CITY OF ALBUQUERQUE

Re: Seven Clover
3641 12th St NW
Site Plan
Architect's Stamp 8-27-23 (G14D062)

Based upon the information provided in your submittal received 12-4-23, the above referenced plan cannot be approved for Building Permit until the following comments are addressed:

AS101

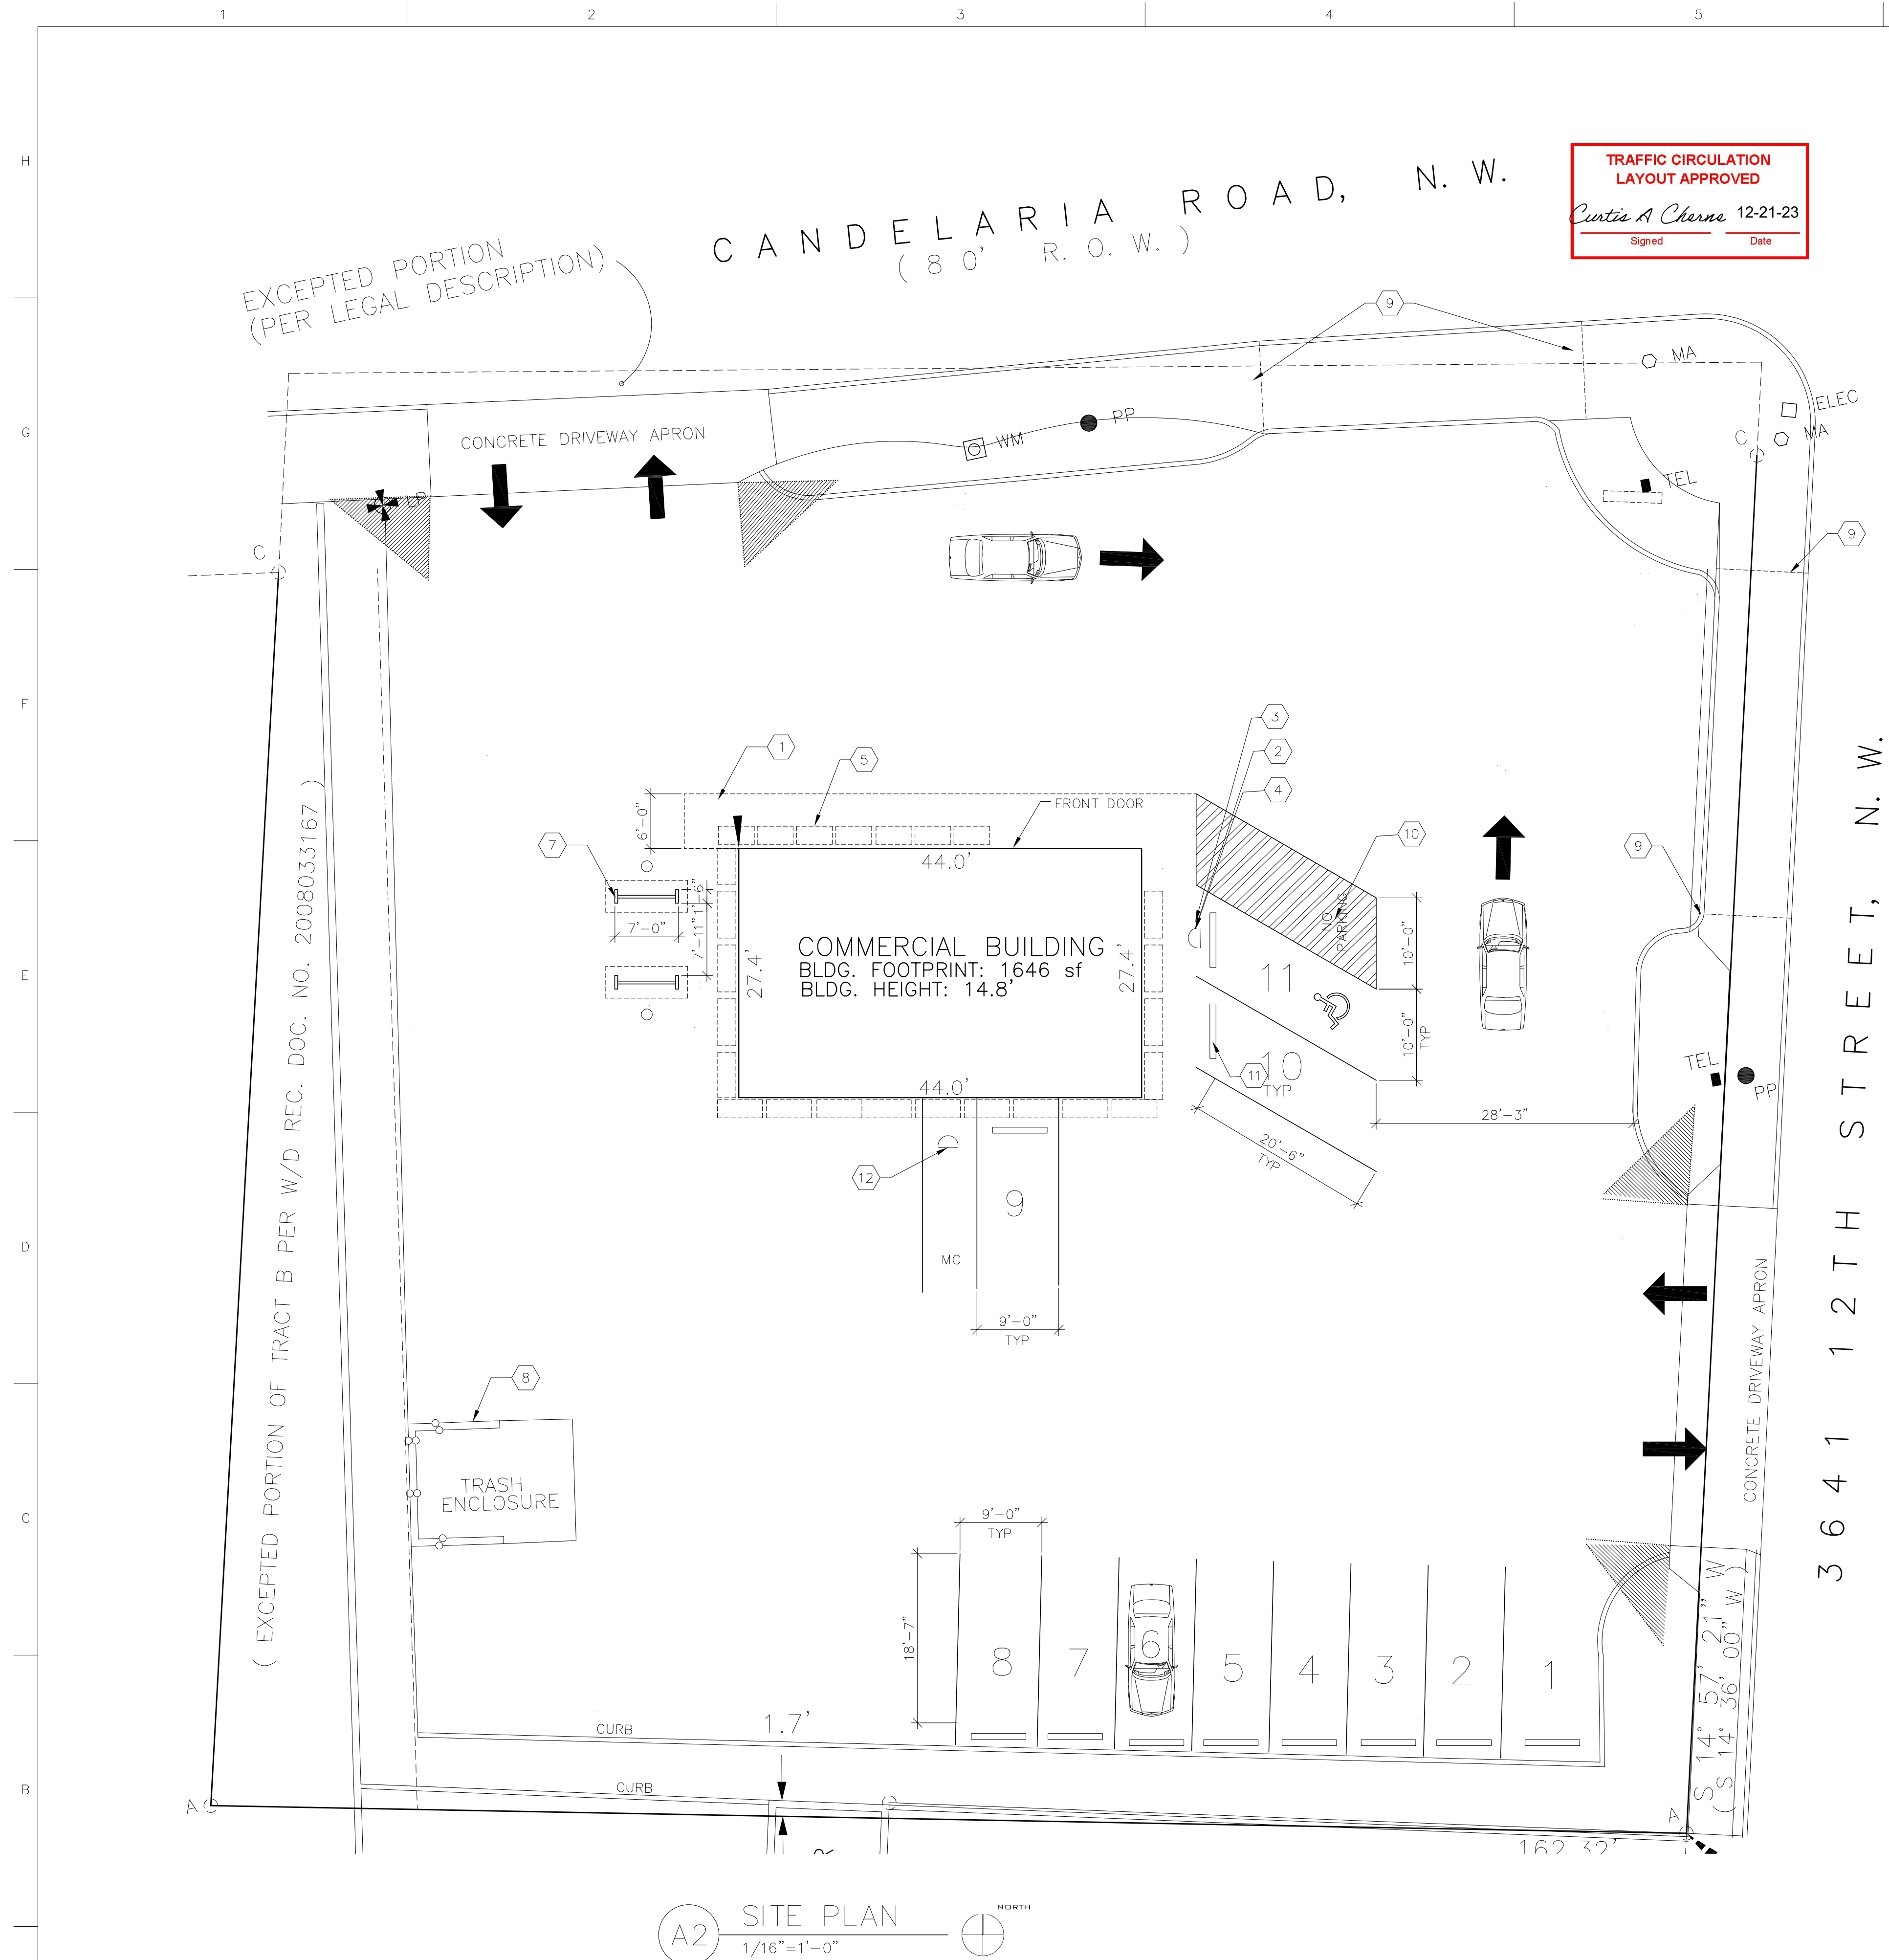
16. Keyed note 5 refers to “2’x5’-2” – gabion...”. Are they to be constructed on the walking surface as shown?
Gabions are owner provided. They will be on the sidewalk near the building.

17. It appears there is a sidewalk to be built around three sides of the building. Provide build notes, including the width. This may necessitate the need for a handicap ramp.
Sidewalk will not be built. Existing sidewalk will remain.

18. Bicycle parking:
- a. Parking is to be separated from vehicle parking areas and driveways by a barrier such as a curb or bollard.
bike parking moved to west side of building. bollards on both sides of the parking racks. Change is clouded with a delta 1.

- b. Keyed Note 7 references Notes 9 and 10 and Detail C6, which don't exist. Please revise note and provide Detail C6.
keyed note updated. There is no note 9 or 10. The bike rack will be owner provided. There is no detail c6. changed is clouded with delta 1.

- c. You will most likely need to provide 3 bicycle parking spaces.
additional bike rack provided. there will be bike parking spaces. change is clouded with delta 1
